From: Martin Hill <Martin.Hill@arun.gov.uk>
Sent: 23 March 2022 18:03
To: Planning.Responses <Planning.Responses@arun.gov.uk>
Subject: RE: Planning Consultation on: BR/57/22/PL

Application No: BR/57/22/PL
Registered: 3rd March 2022
Site Address: 18-20 Stocker Road Bognor Regis PO21 2QF
Grid Reference: 492662 98747
Description of Works: Demolition of vacant garden building and construction of 1 No. 2 bed supported accommodation annexe.

PROPOSED GROUND FLOOR PLAN 1:100

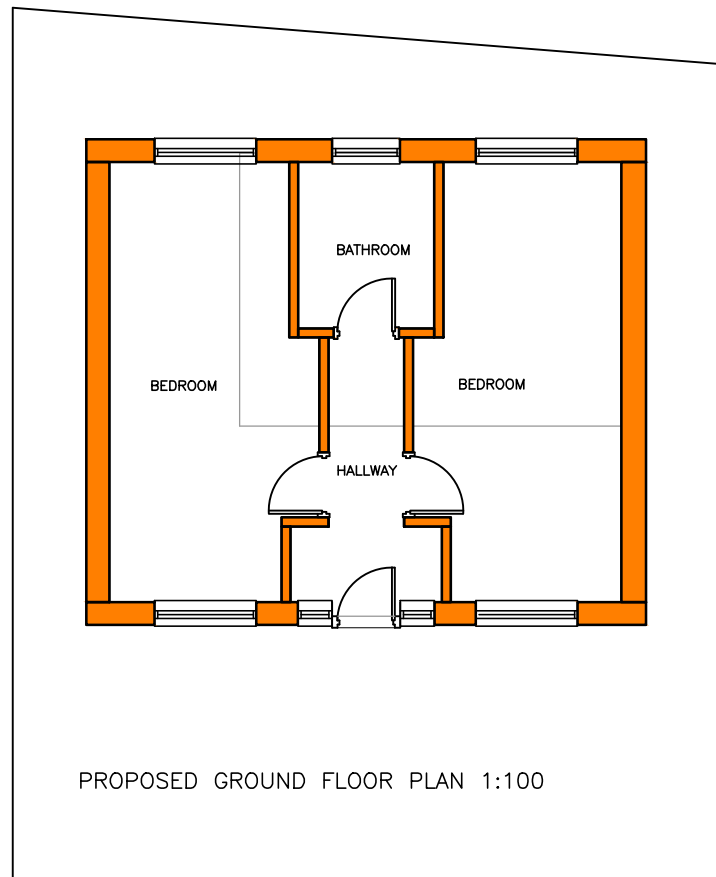
The proposal for this unit, which appears to be absent of cooking facilities within the new building would suggest that occupants would need to traverse outside of their accommodation into open air and then into the main building to access kitchen facilities. It must be considered that occupants have the right to access kitchen facilities at any time of the day and at any time of the year and with this in mind it is the opinion of Private Sector Housing that the applicant should either consider including cooking facilities within the new unit, either as a communal facility or individual cooking facilities provided within bedsits. If this is inappropriate for any reason, consideration should then be given to linking the new unit with the main building, providing warmth and shelter during inclement weather for when occupants may choose to use the facilities in the main building.

- There must be an external emergency escape route provided from the proposed unit which leads to a place of ultimate safety, without the need for entering another building and which must have adequate emergency lighting to the escape route and any exit gate installed

- Room sizes should meet the minimum standards for Houses in Multiple Occupation.
- The floor to ceiling height must be at least 2.1 metres from floor to ceiling over at least 50% of the floor area when measured at a height of 1.5metres from the floor and provide sufficient useable space.
- Note:
With regards to room sizes where separate dining space is provided elsewhere:
6.51sqm – suitable for 1 person
10.2sqm - suitable for 2 persons

- Any bathrooms and kitchens without windows for natural ventilation should have adequate mechanical ventilation.
- All habitable rooms must have an opening window, equivalent to 1/20th of the floor area, to the outside air to provide adequate ventilation. French or patio doors that have no separate openable casements, or where there is no alternative openable casement within the room, are not considered acceptable in bedrooms.
